Office of
Environment
& Heritage

DOC18/286239
MP09_0180 MOD 7

OEH comments on Modification Seniors Living Housing Development, 34-36 Memorial Avenue, Kellyville (MP09 0180 MOD 7) – Response to Submissions

OEH comments on Modification Seniors Living Housing Development, 34-36 Memorial Avenue, Kellyville (MP09 0180 MOD 7) – Response to Submissions

Landscape Concept Plan

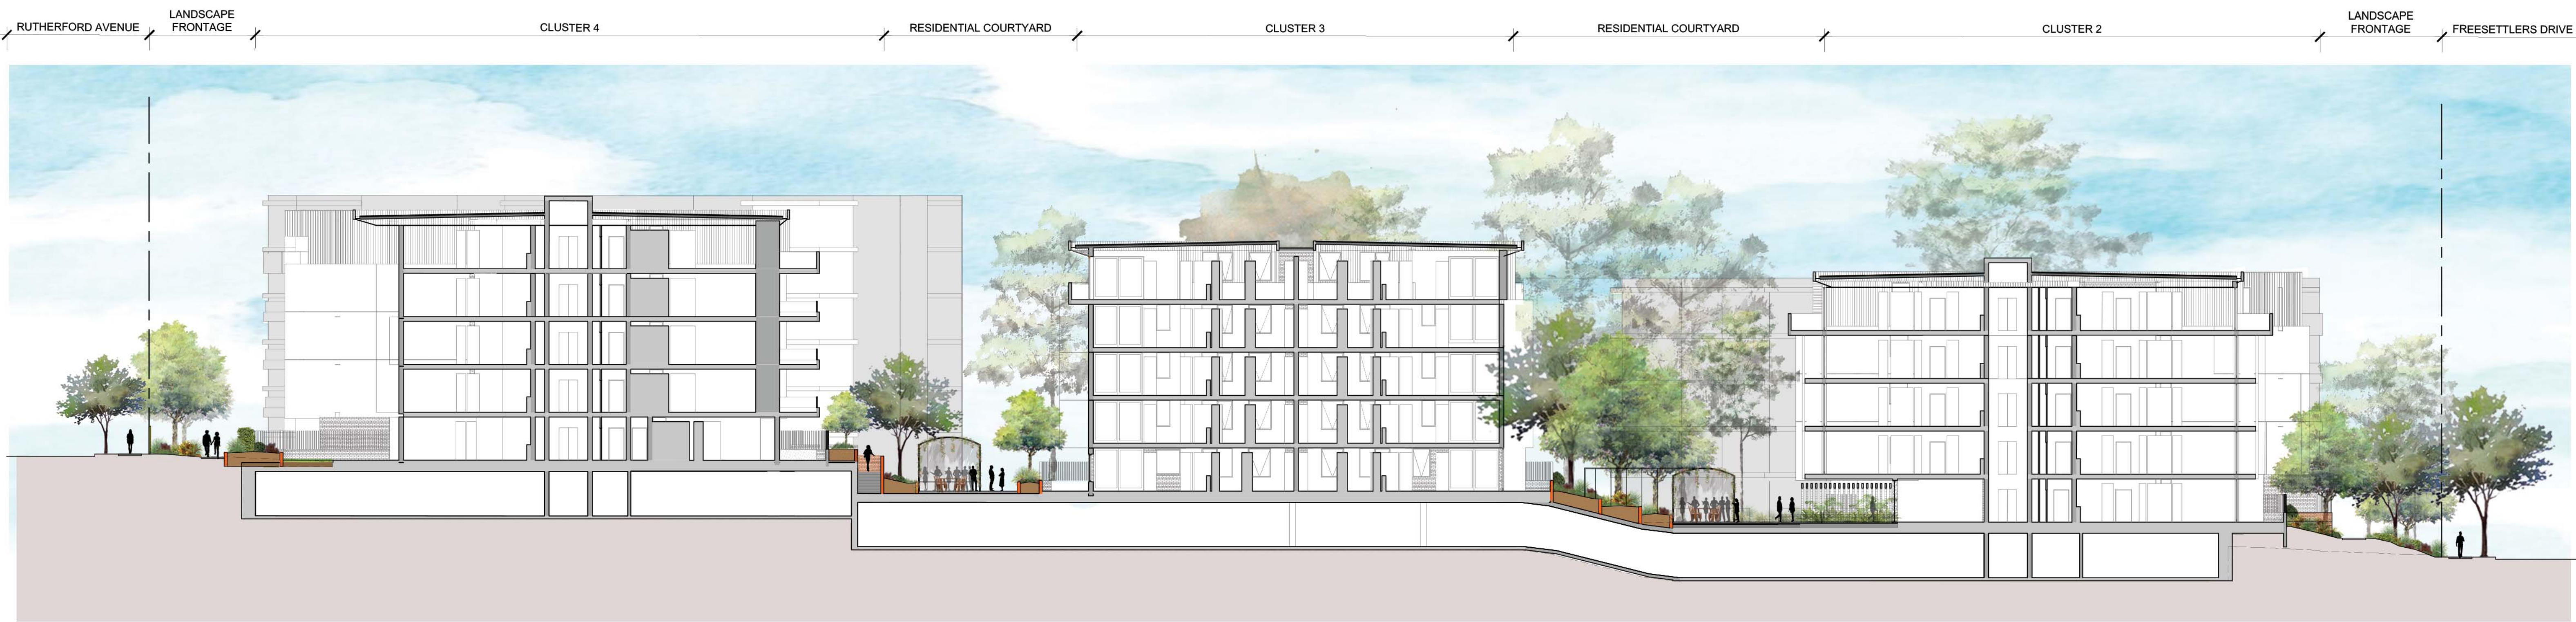
OEH supports the replanting of 28 new trees on the site but it is unclear if they are planted in the 10m defendable zone if they will be protected in the long term once the trees grow to maturity, or if they will require removal or lopping in the future due to bushfire risk/hazard reduction purposes. If there is potential for the trees to be removed/lopped from within the defendable zone, it is recommended they are planted in the CPW reserve, as the reserve is meant to be managed in perpetuity for conservation purposes and the following condition of approval is included in the development consent:

The Cumberland Plain Woodland Extent plan shows that part of the CPW will incorporate a 10m defendable space which includes slashed native grass. It is unclear what will delineate the CPW to protect it from maintenance slashing encroaching into it where it is located adjacent to the 10m defendable space. The proponent needs to clarify if the 10m defendable space is to be managed differently to other parts of the CPW reserve area, and if so how will the CPW areas outside the 10m defendable space be delineated and protected from slashing.

- *28 new trees consisting of local provenance CPW species are to be planted within the CPW open space reserve within 3 months of obtaining development consent.*
